RE: Review Comments for Single Family Site Plan

Project Name: McDonald Two Family
Project ID: 2016-02072
Project Address: 84 Irving Street **CBL:** 137-A-001001

Drawing file: 1.  Original Plans / Existing Conditions Survey.pdf

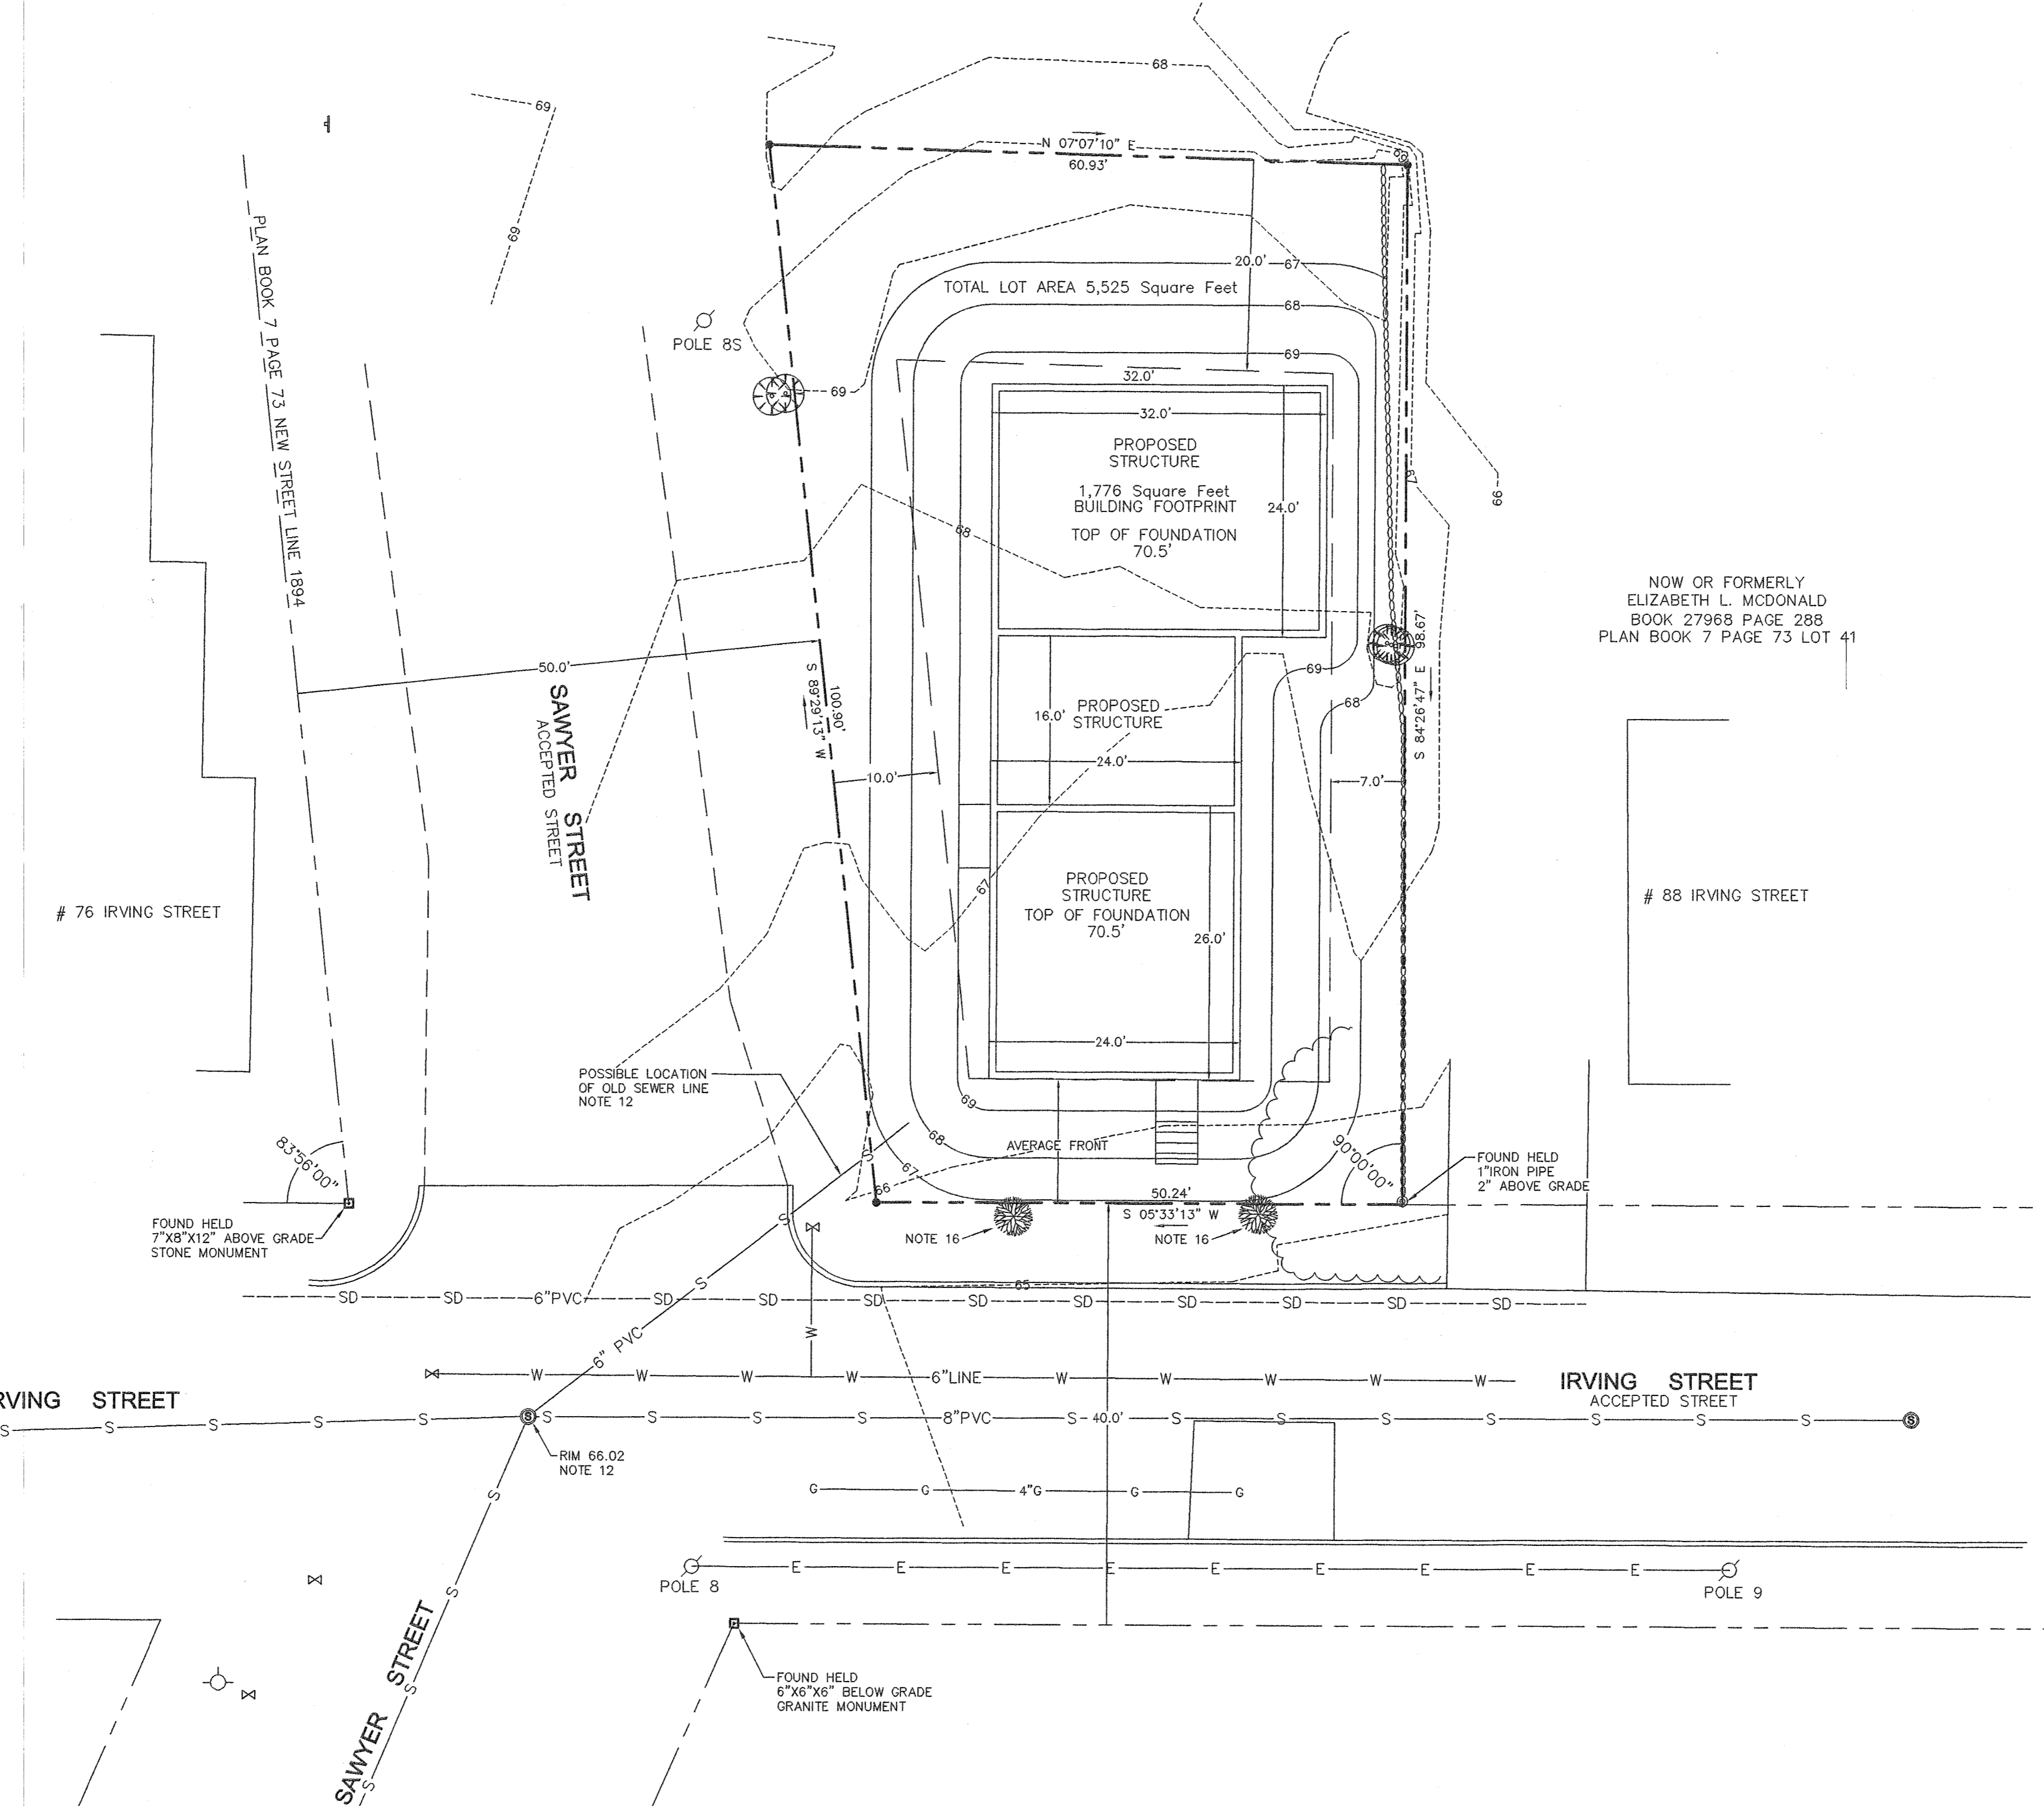
1. Please submit a clear and legible revised survey that meets the following survey standards for a Level I Minor Residential site plan application:
 - Name and address of the property owner, the applicant, and name of the proposed development, with references to the Deed Book and Page at the Cumberland County Registry of Deeds.

- Property Corners: Location and descriptions of all property corners set or found, proposed to be set, and all granite survey monuments set. Where no property markers exist, the City of Portland requires that the property markers be installed, and that a licensed surveyor set and confirm the proposed building corner locations on site, prior to the issuance of a building permit.

- SEE NOTE 1 → • Please show the existing and proposed paved driveway areas.
- SEE NOTE 2+3+5 ← • Please add the locations of all proposed utilities from the street to the structure, including the electrical service, to the site plan.

- SEE NOTE 6 ← • Please add the NRCS soil type to the site plan.
- SEE NEW SITE SURVEY ↗ • Please revise the grading plan so that it is clear that neighboring properties are not negatively impacted by stormwater surface drainage, ie. adding drip edge around the foundation, berming and swaling so that stormwater is directed to the front of the site towards the street, etc.

- SEE NEW SITE SURVEY ↗ • Please add to the site plan, the required erosion control measures ie. silt fence or erosion control mix (erosion control plan) in the appropriate areas.

- SEE NEW SITE SURVEY ← • Please add to the site plan, the location, area, and limits of the proposed site disturbance.
- SEE NOTE 4 ← • Please show on the site plan where the foundation drain will outlet.

SEE NEW
SITE SURVEY

SEE NEW SITE SURVEY
